Arun District Council
Arun Civic Centre
Maltravers Road
Littlehampton
West Sussex BN17 5LF
Planning & Building Control General Enquiries
Tel: (01903) 737756 Fax: (01903) 730442
Dx: 57406 Littlehampton
Minicom: 01903 732765
e-mail: planning@arun.gov.uk
website: www.arun.gov.uk/planning

Application No: FP/213/21/T
Site Address: 108 Limmer Lane Felpham PO22 7LP
Description of works: 1 No. Lombardy Poplar tree (T1) - re pollard to previous points. 1 No. Norway Maple tree (T2) lateral prune to source 3-4 lower branches heading east over the boundary wall. 1 No. Lime tree (T3) lateral prune to source 2-3 lower branches heading east over the boundary wall.

Comments from Felpham Parish Council Tre Warden:

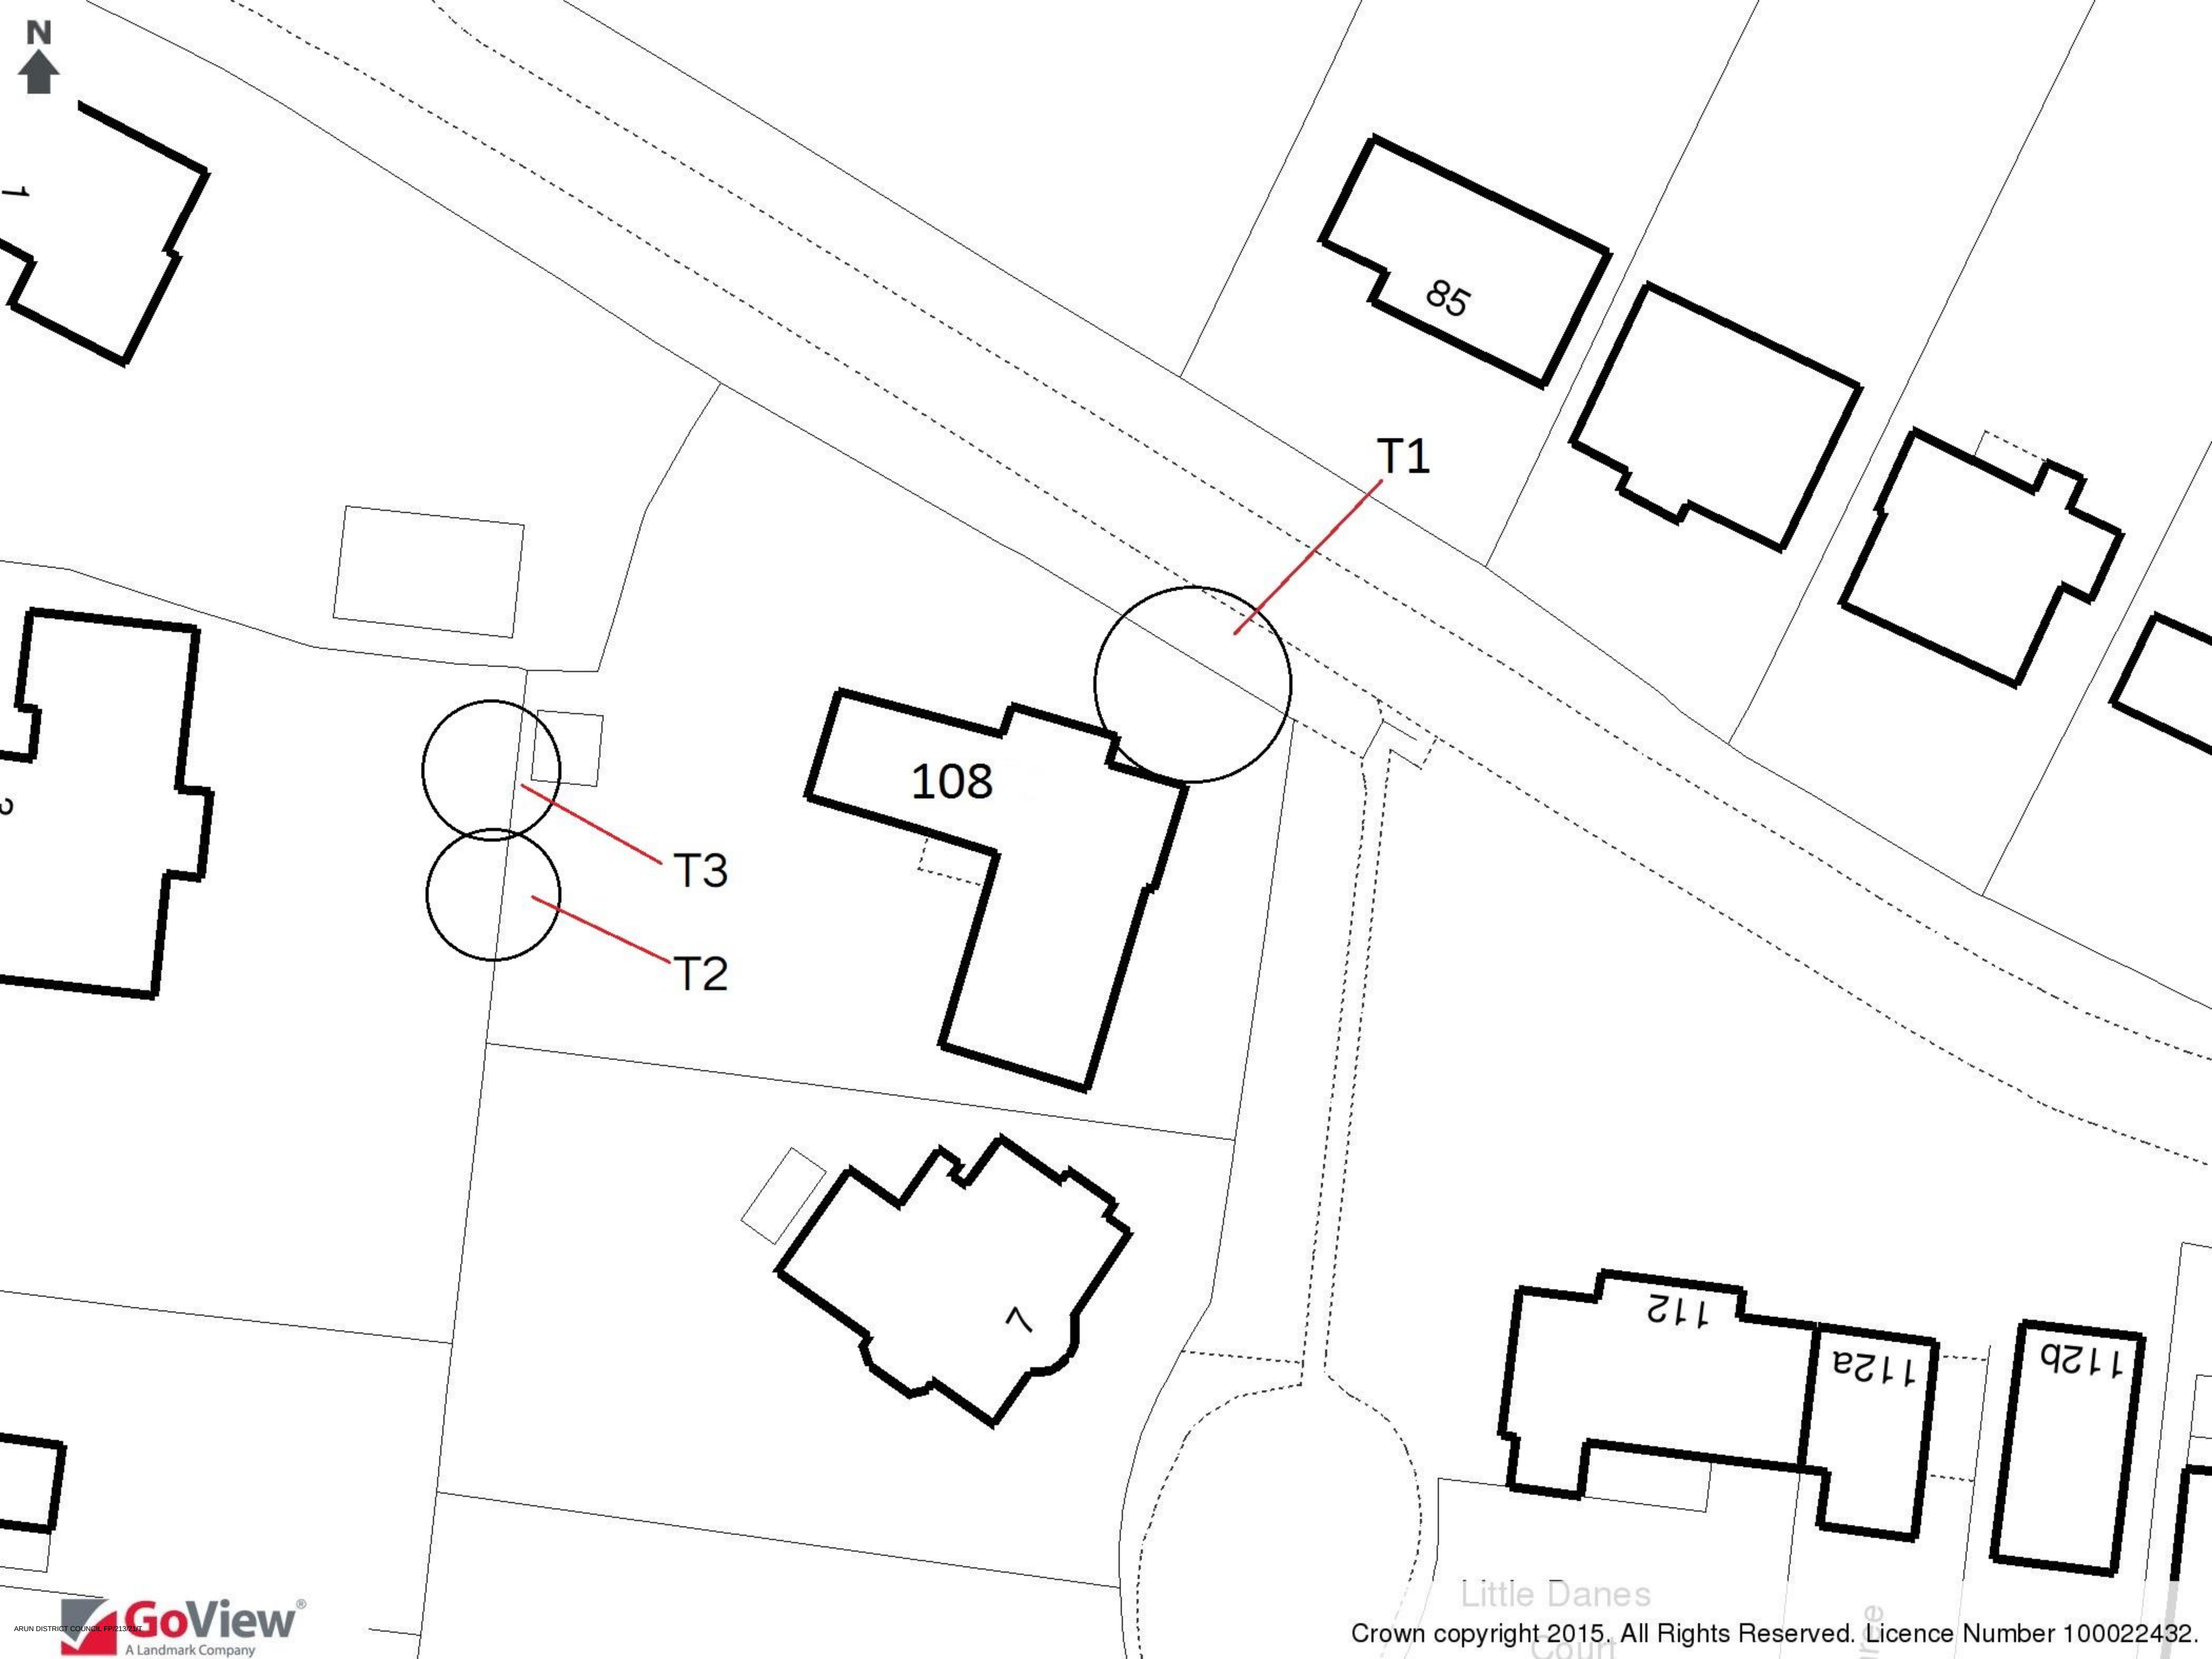
'108 Limmer Lane: Requested works seem appropriate - T1: reduce to previous pollard points seems fine but owner should regularly monitor compromised wood (particularly on northern side) given nearby location to road. Works to T2 and T3 are reasonable'.
